ENGINEERING & TECHNOLOGY PRECINCT (ETP) REDEVELOPMENT – PHASE 1

DESIGN EXCELLENCE REVIEW PANEL (DERP) - MEETING No. 4

31 August 2018, 10.00am – 12.00pm

University of Sydney Engineering and Technology Precinct - Stage 1

Atrium Components

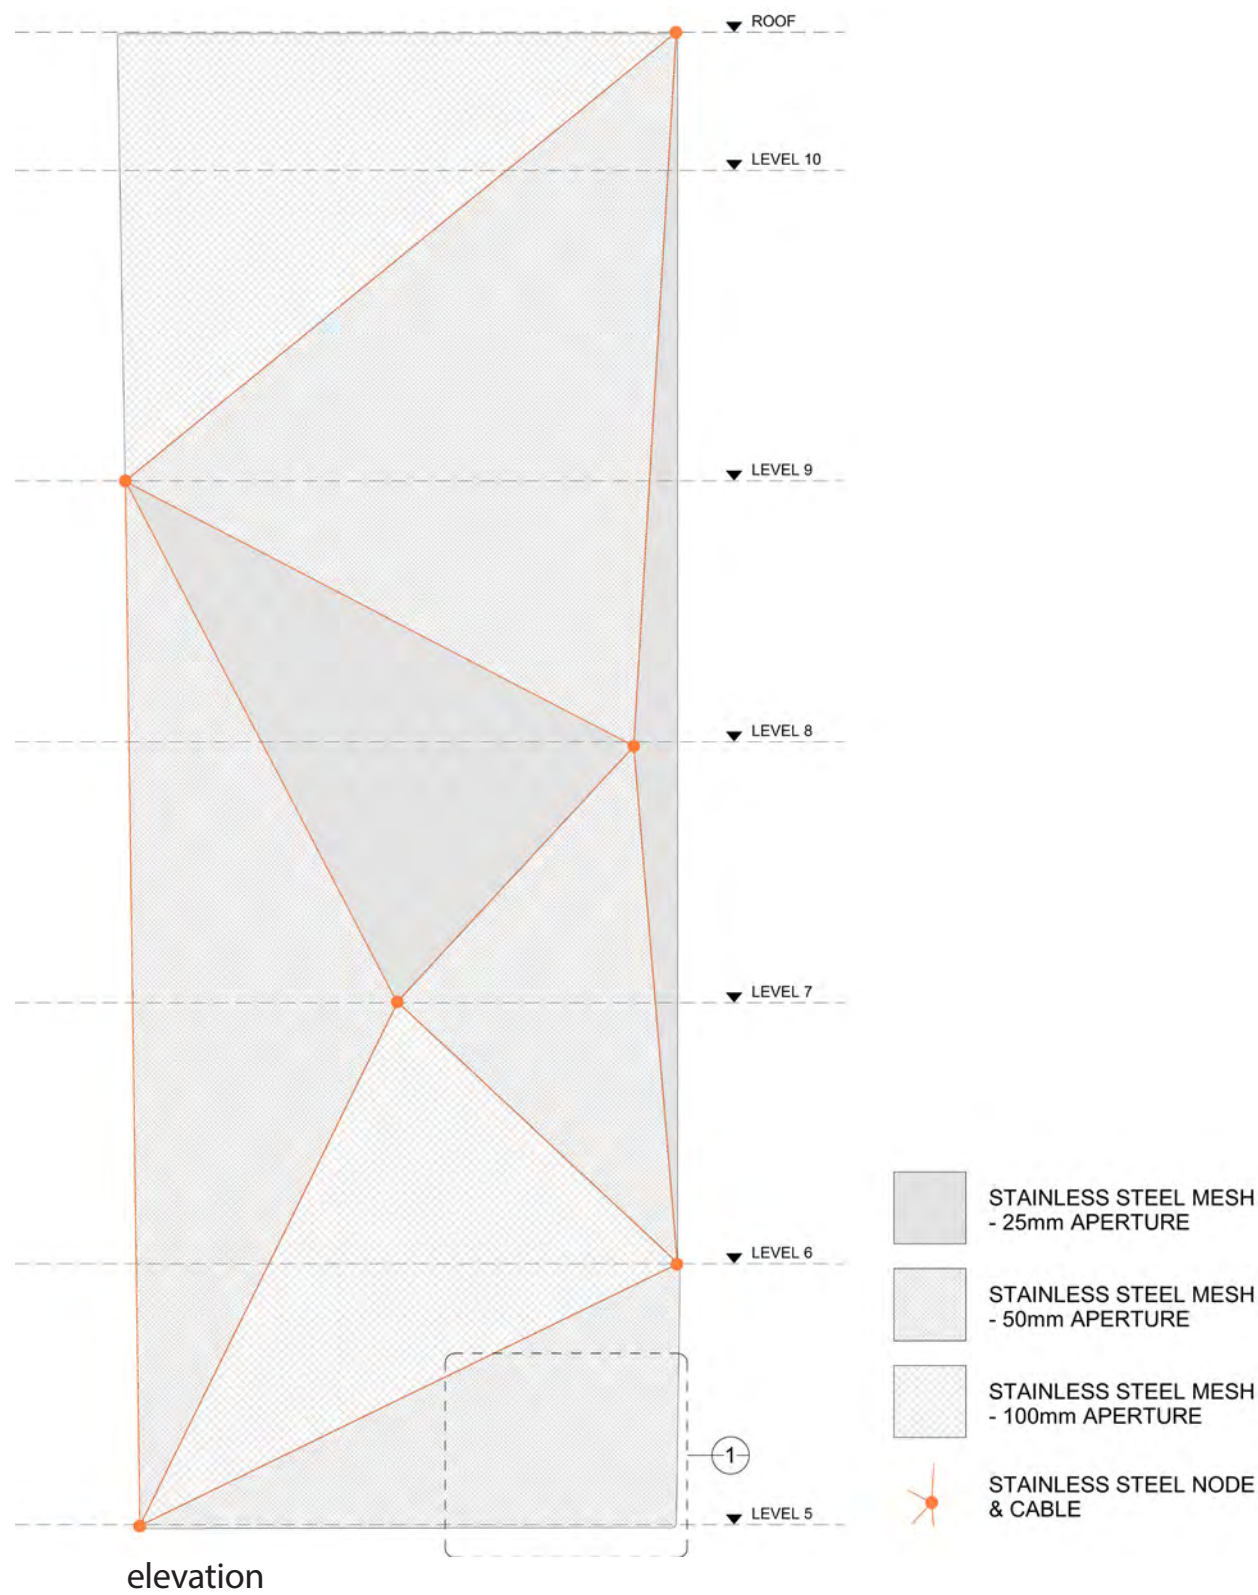
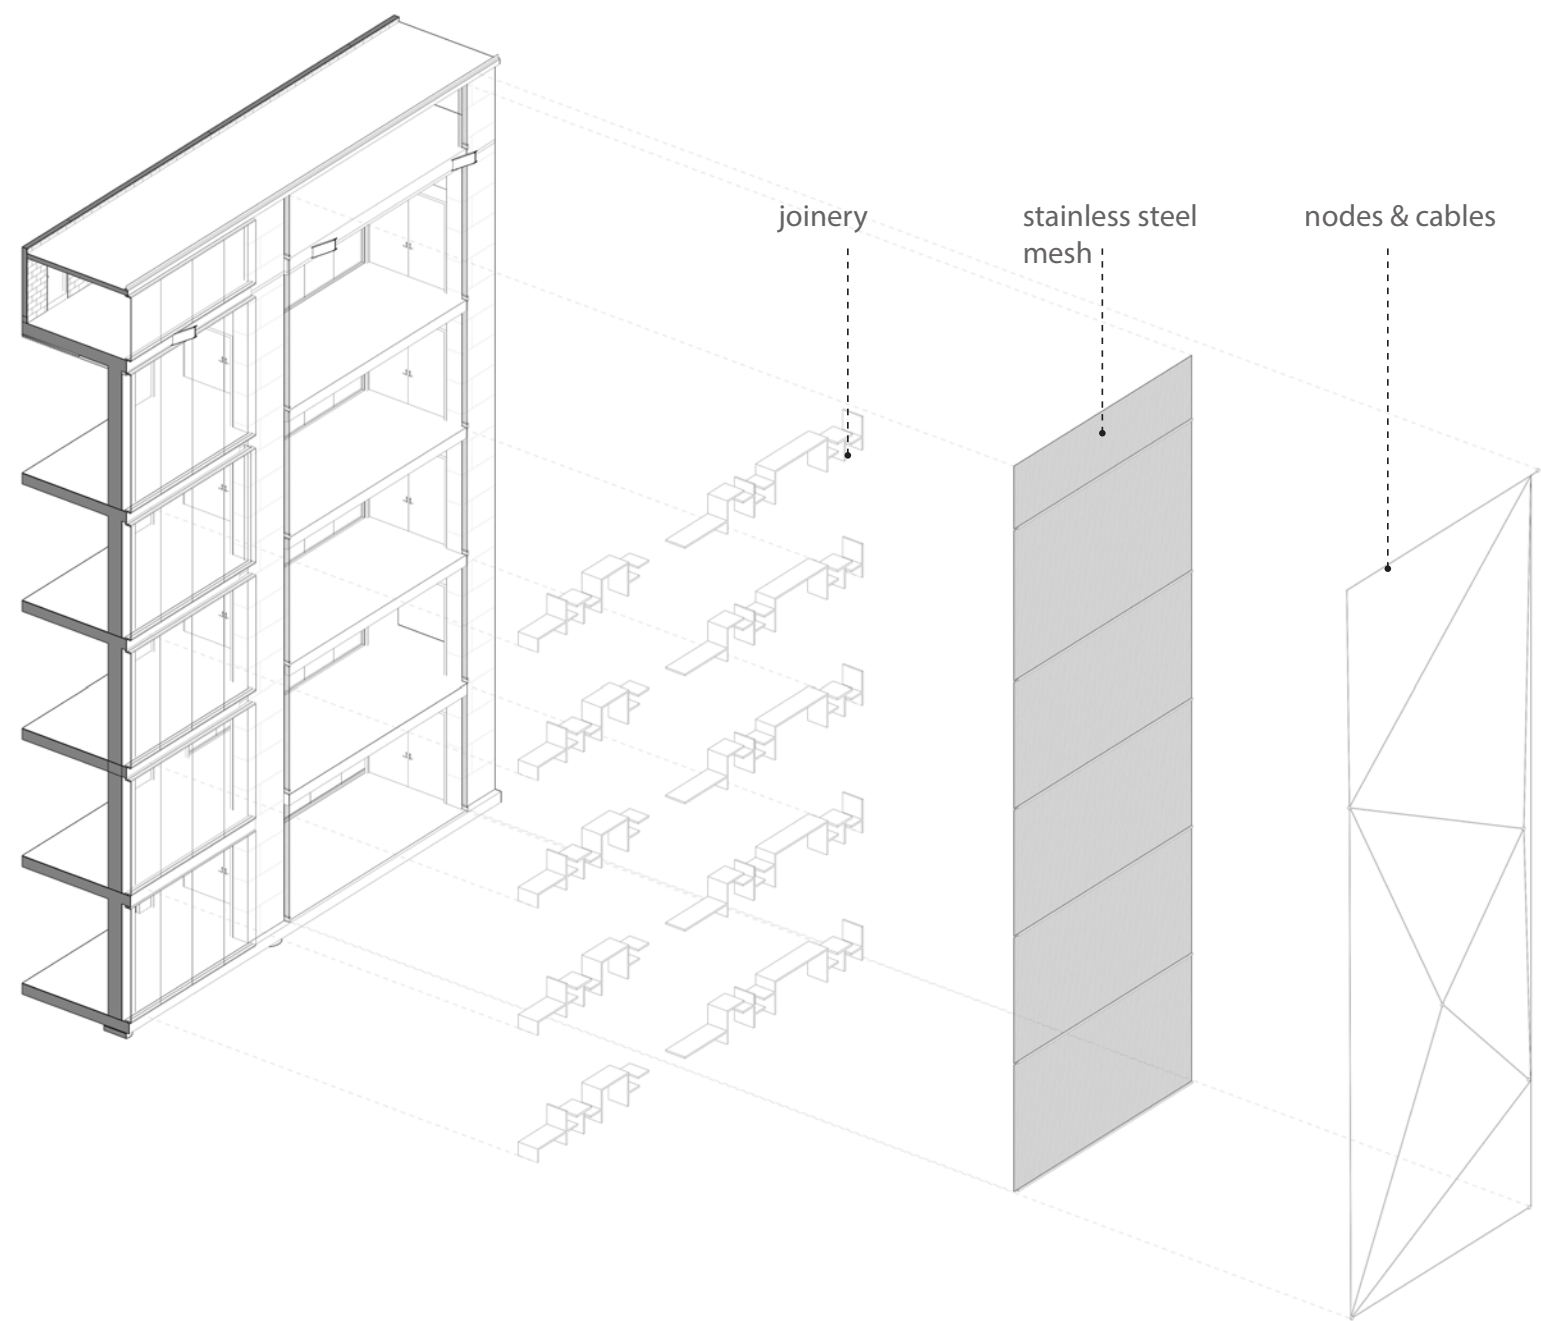
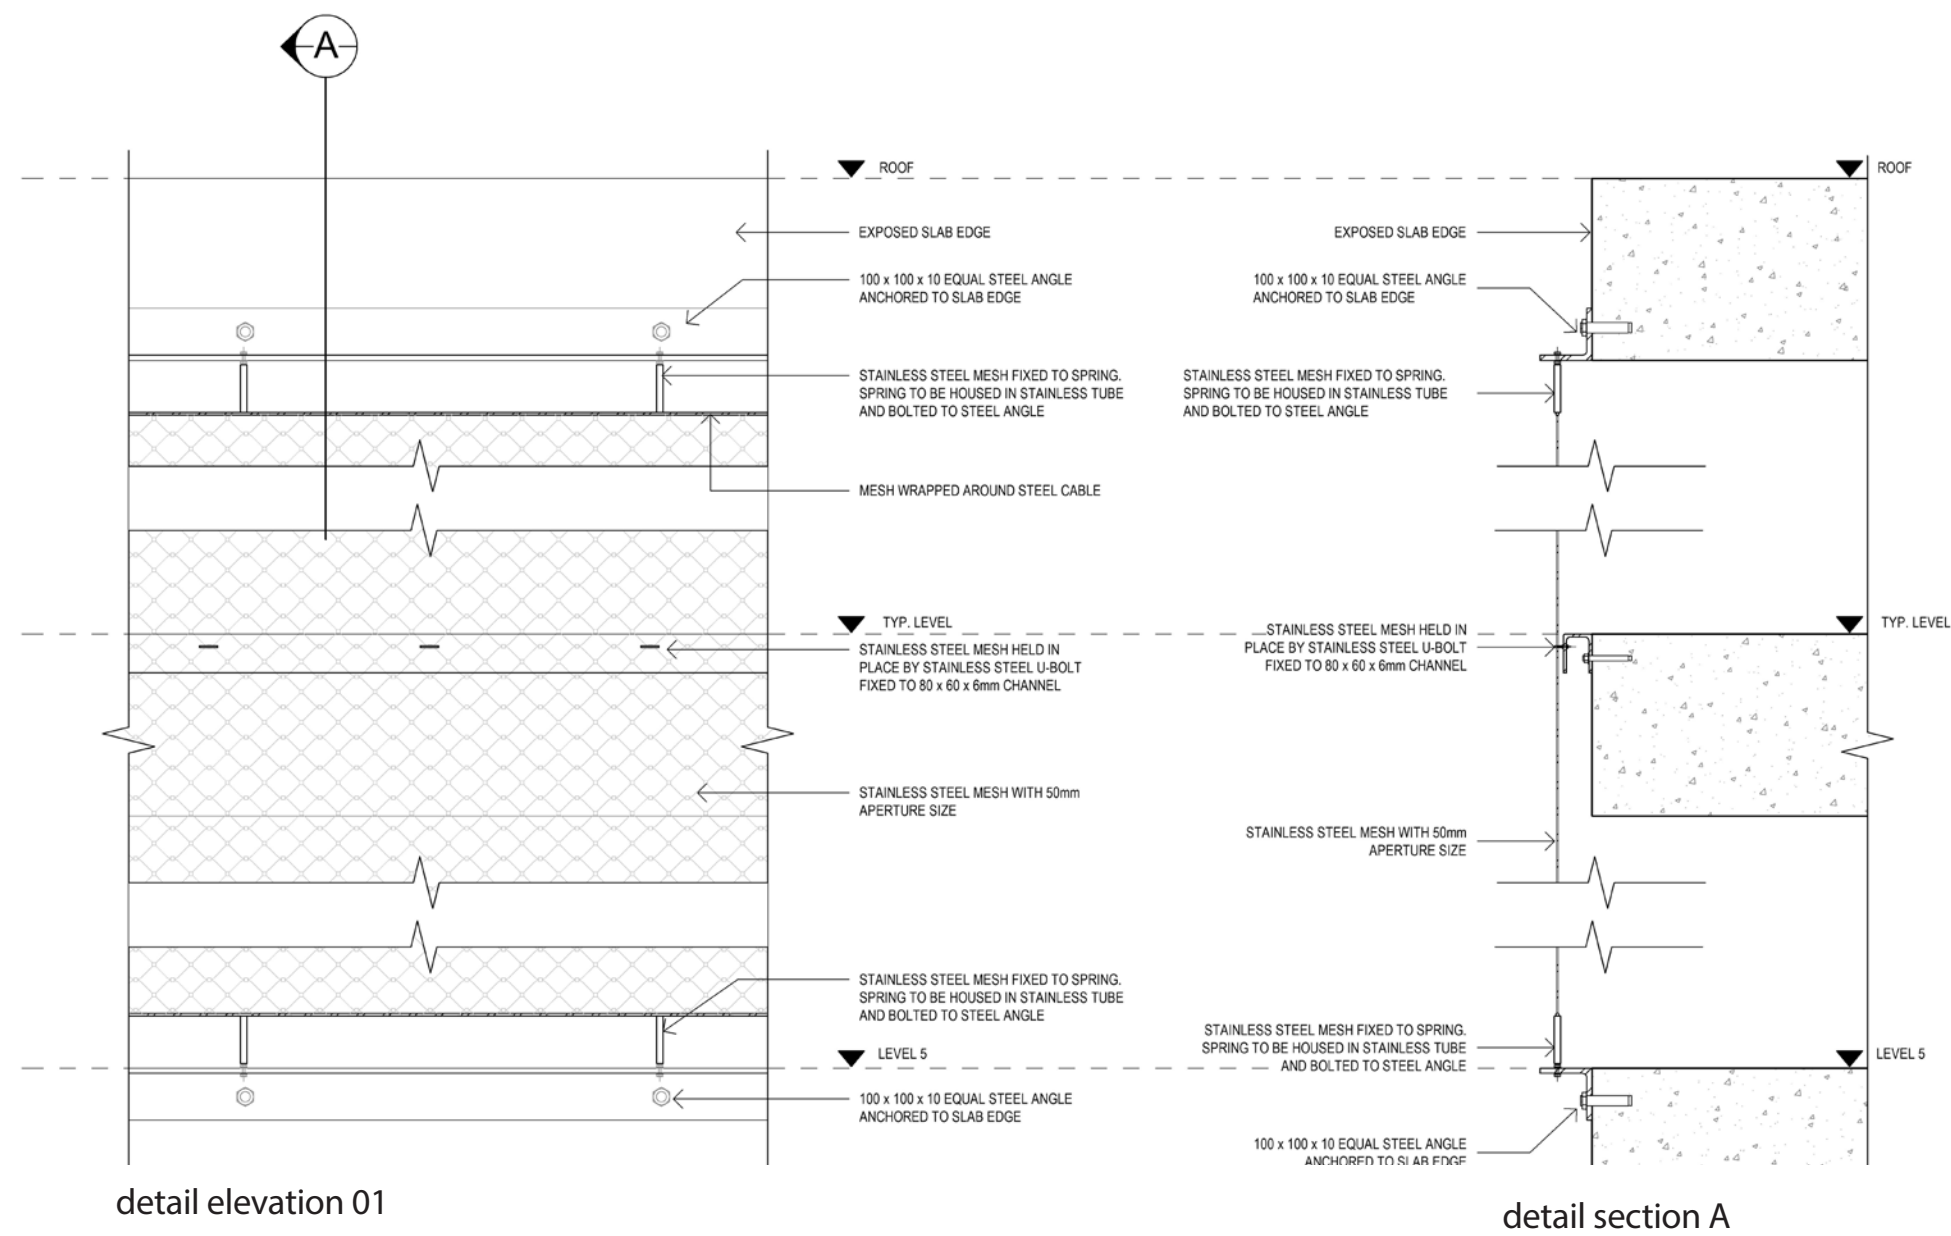
<p>7. Further detail required for the mesh to the atrium, and edge condition.</p>	<ul style="list-style-type: none"> • Refer to sheets 50 to 63. • Mesh has moved to the other side of the atrium. • Provided an overview of the form of the mesh and its differing gauge dimensions and connection detail to the slab. Continued representation of constellation with nodes. • Joinery aligns with the mesh. 	<p>Generally acceptable to DERC. Horizontal loadings and rigidity of screens to be investigated.</p>
<p>8. The external ducts on north façade to be reviewed in terms of aesthetic and materiality</p>	<ul style="list-style-type: none"> • Refer to sheets 42 to 48. • Provided an overview of the refined Engineer solution. • Presented a model of the external louvre connections. • Noted ducts can be removed and replaced if required. 	<p>Generally acceptable to DERC. The Panel looks forward to further design development and refinement of the external ducts materiality, detail and geometry.</p>
